**DEVIATION REVIEW
 AND DECISION FORM**

Deviation No. 4
REV. 2-8-2019

Subdivision or Project Name: Rollin' Ridge Estates

Proposed Nature and Extent of Deviation: Allow abbreviated (shorter than ECM standard) westbound left-turn lane and taper lengths on Hodgen Road at the Cherry Crossing Drive intersection.

C1.3

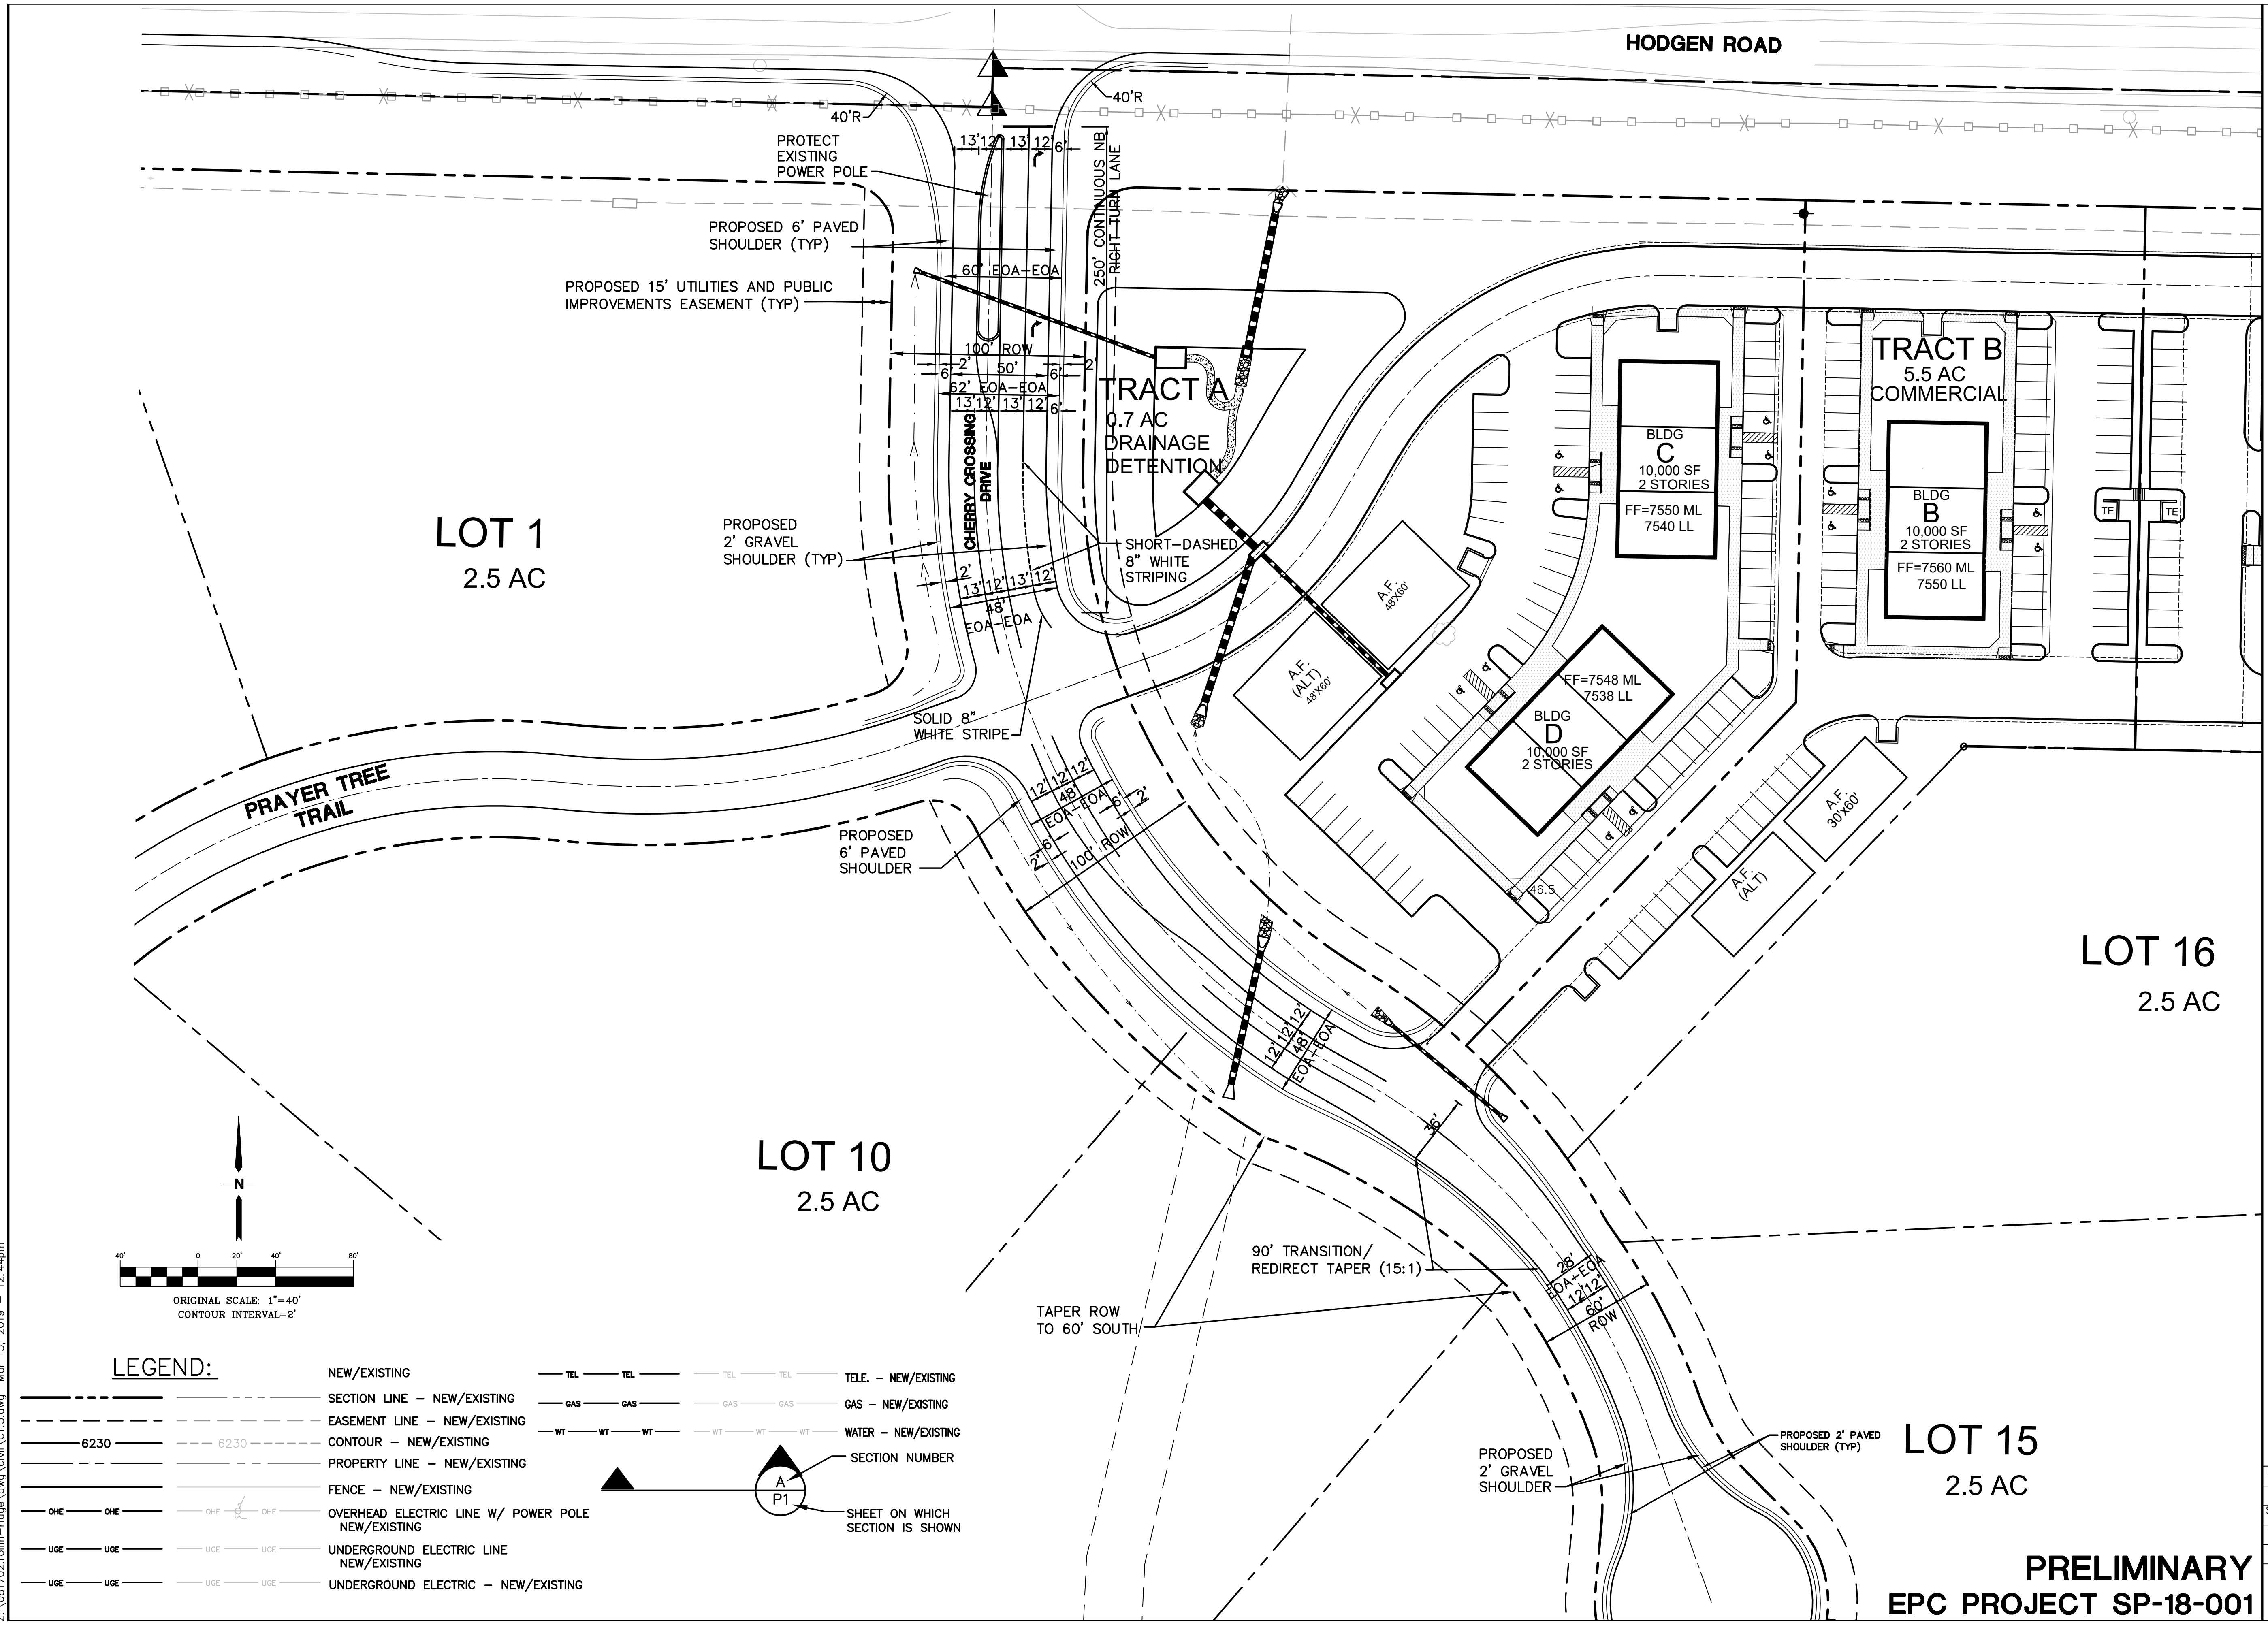
Please Refer to updated Cherry Crossing Drive Entry Detail (C1.3) by JPS dated 1-14-2019
